From: [Terry Vincent](#)
To: [Clare Howe](#)
Cc: [Planning](#)
Subject: Ref: 6/2019/0108/PN11
Date: 30 January 2019 13:35:53

I will need to see a BS4142:2014 noise assessment regarding the motor vehicle repair shop adjacent to the development site. I am concerned that this could have an impact on the closest façade of the proposed development. As there is some time before the deadline for this application I wanted to give the applicant a chance to submit the report before the consultation period expires.

Figure A1 – Extract Drawing Indicating Measurement Locations

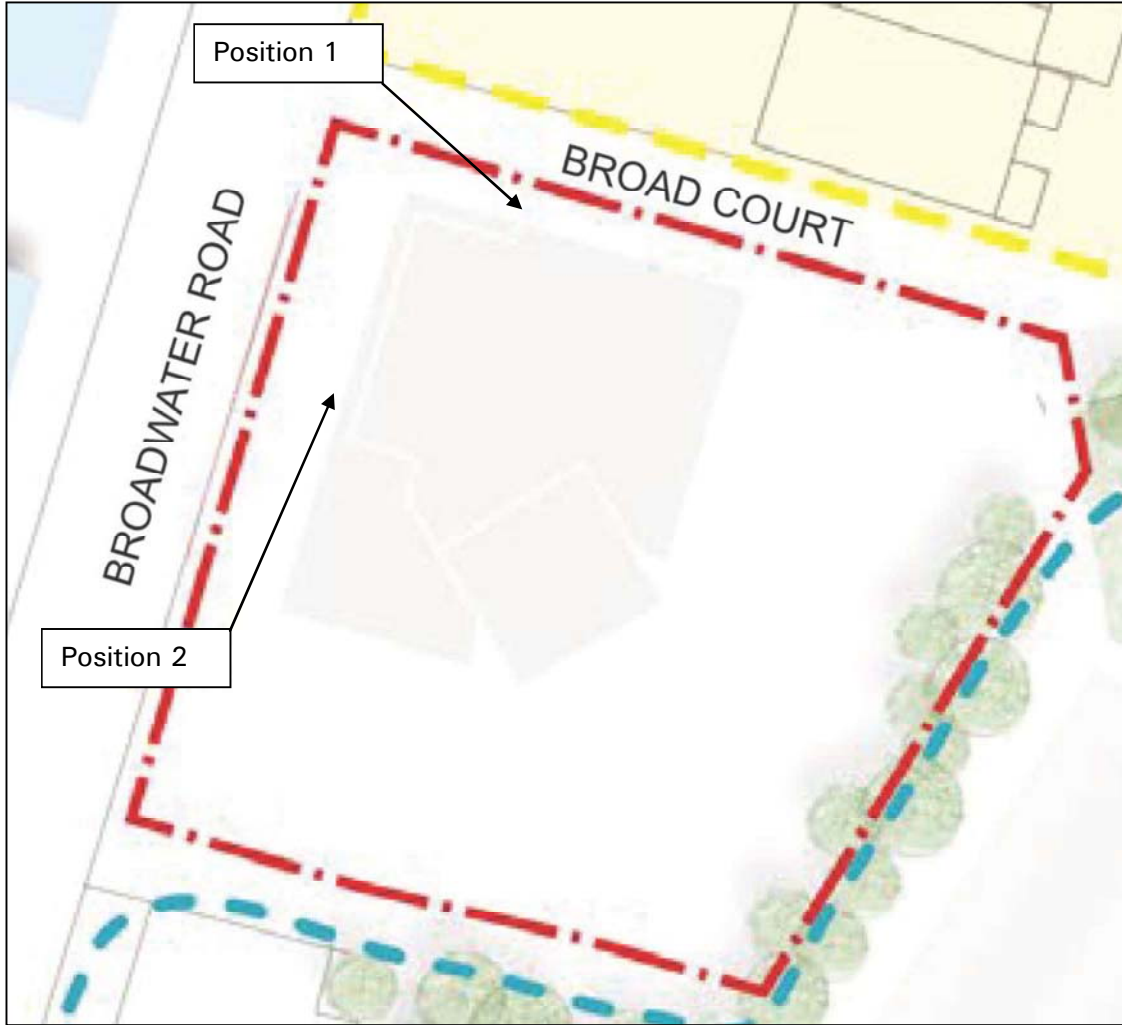
I would also like the noise consultant to provide me with the 15minute LAeq data from the monitoring period.
